From: oliver.perceval <[REDACTED]>
Sent: 23 July 2026 15:34
To: Rhiannon Lloyd <Rhiannon.Lloyd@arun.gov.uk>
Subject: Re: Y/42/26/L Bonhams Farm House

Drawing No.
KD.010D

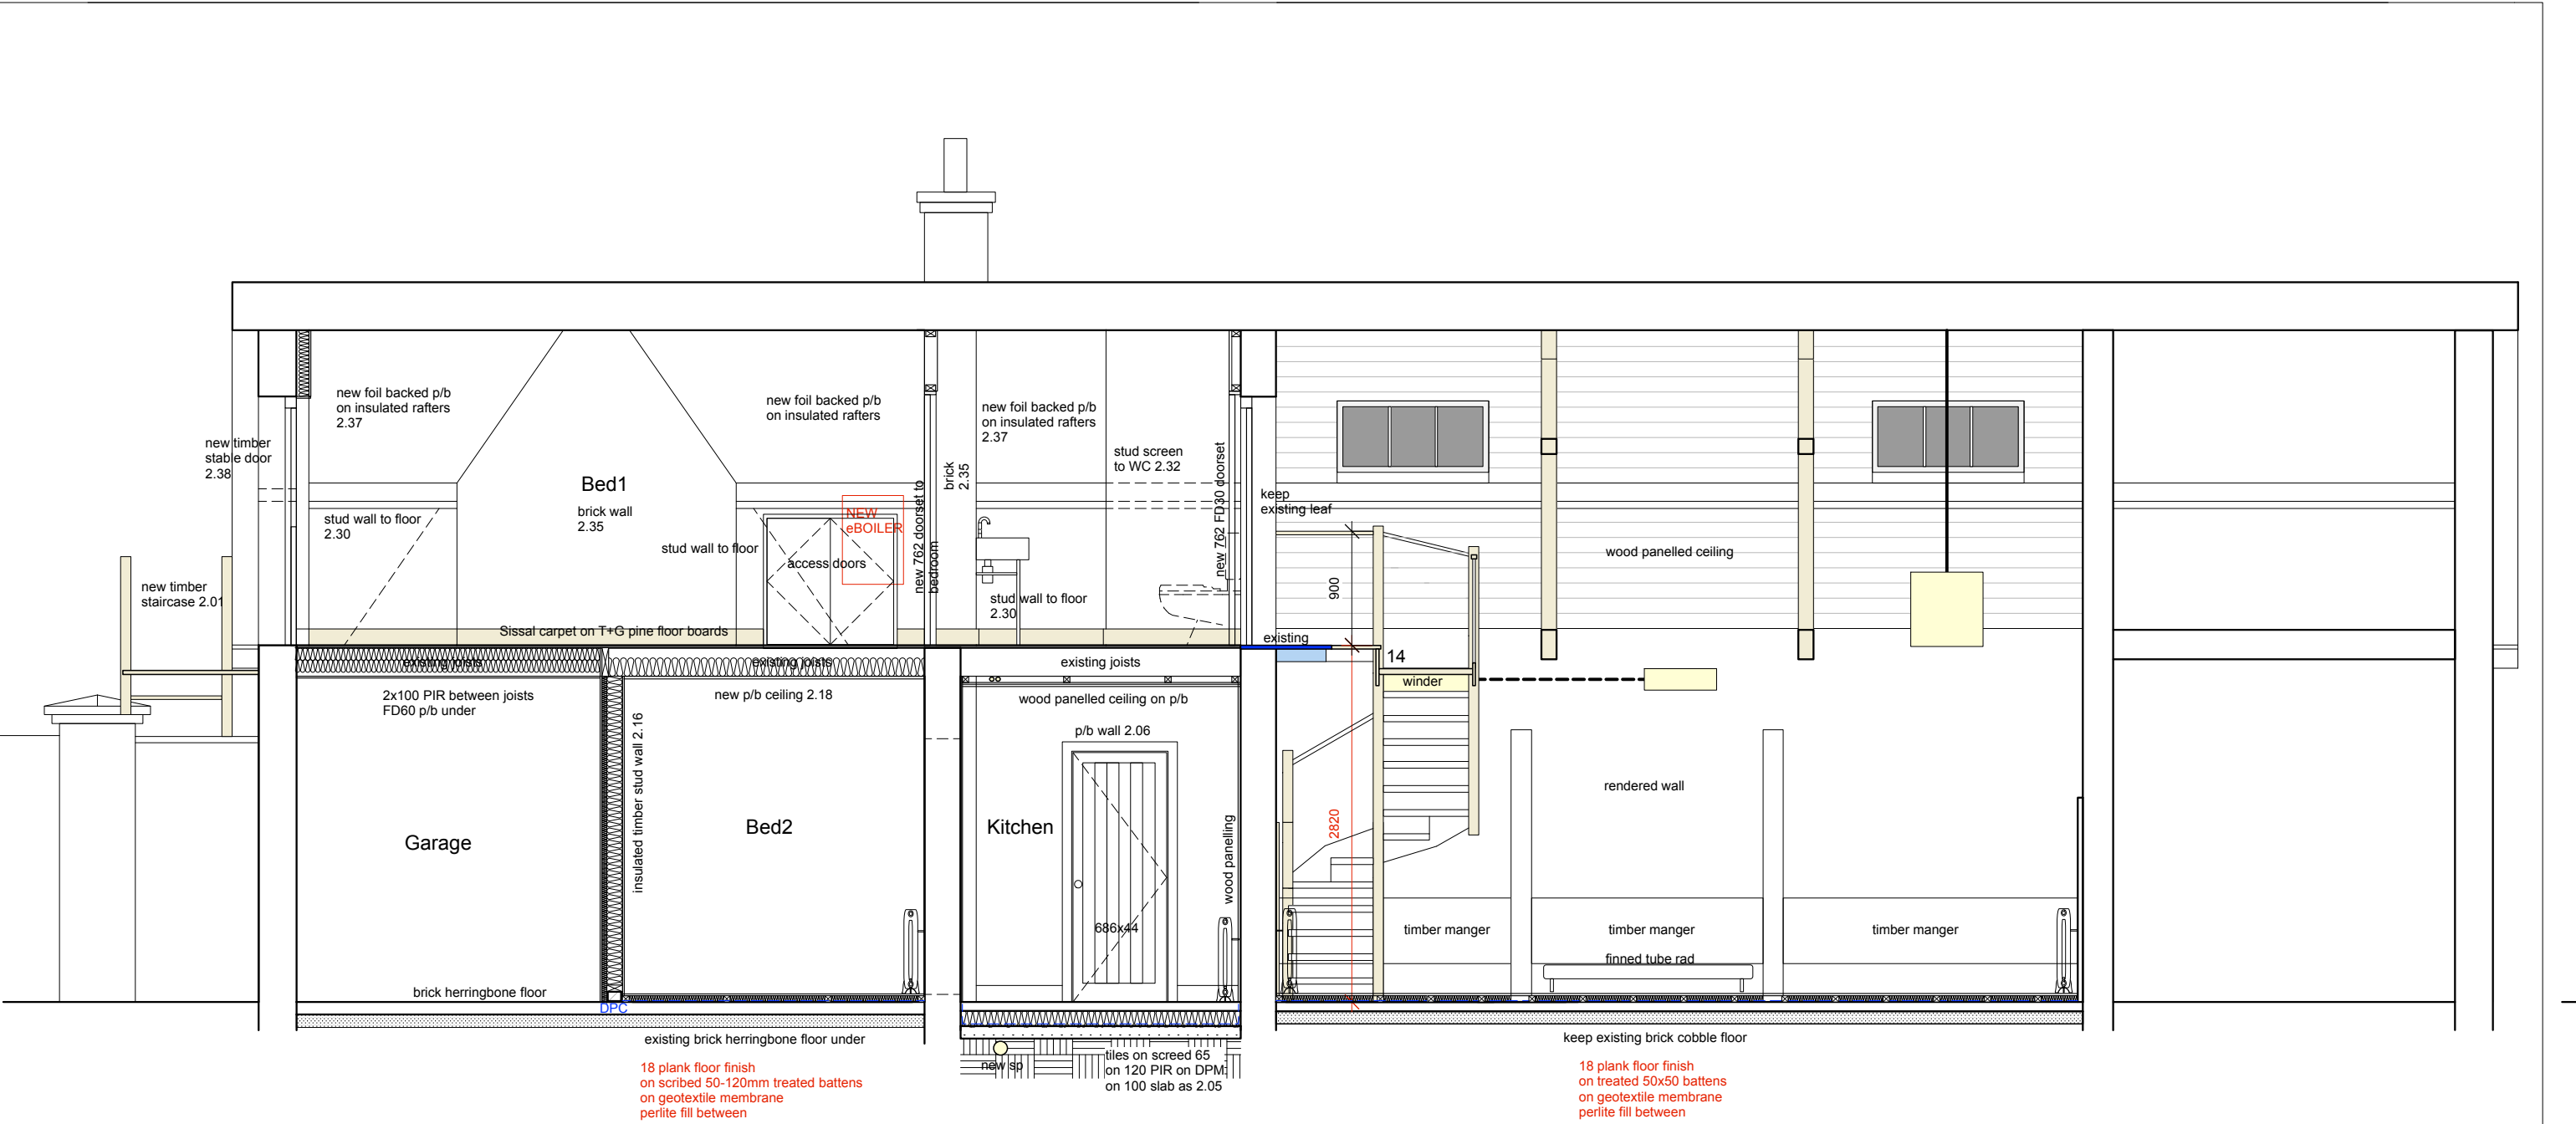
Further, please provide confirmation RE the proposed timber flooring, specifically:

- Whether it would allow the existing historic floor beneath to breathe and avoid moisture-related deterioration.
- Confirmation that no fixtures or fittings would be attached to the retained brick cobbles.

Garage / new bedroom2

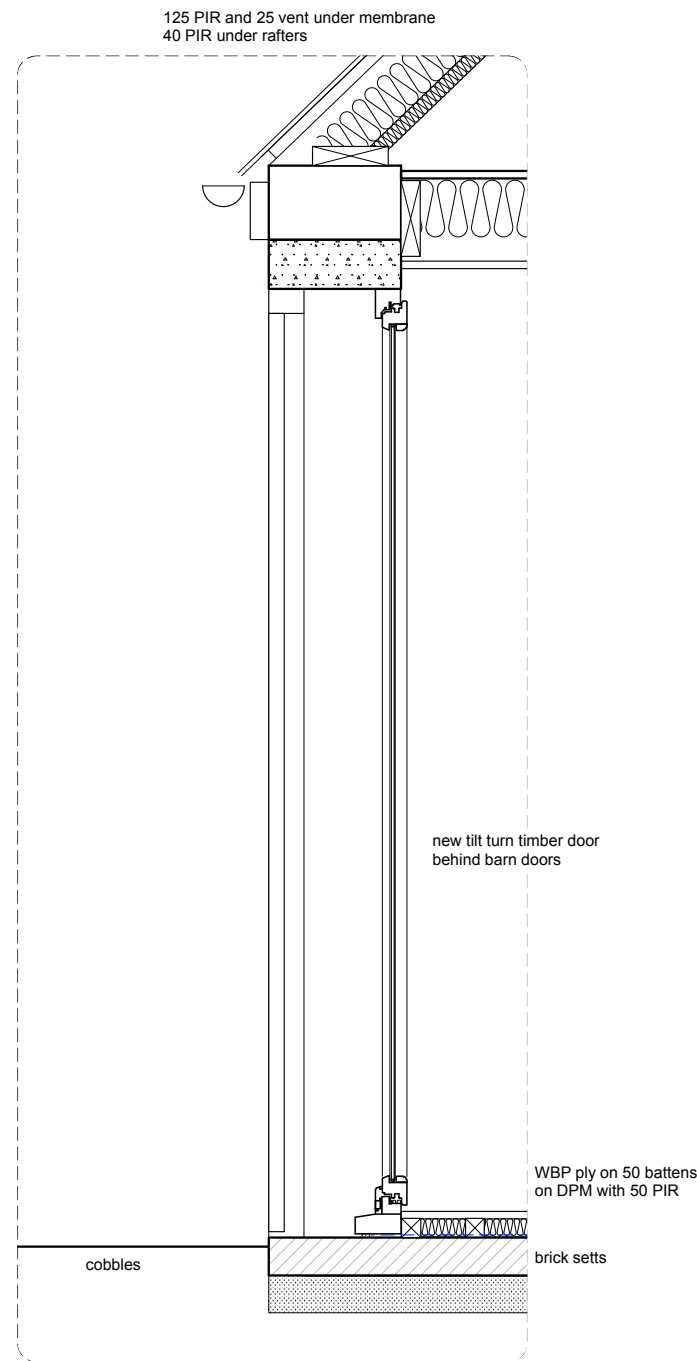
Key concerns below regarding the below door/window details could be secured via condition; requiring full details of all proposed windows and doors, including their design, appearance, glazing, opening method, finish, and positioning within the reveal, to be submitted and approved prior to their insertion.

- No elevations or detailed drawings have been provided showing the appearance of the proposed double-glazed timber door/window behind the garage doors. Only the closed garage doors are shown on the submitted plans.
- Further details are also required for the proposed stable door.
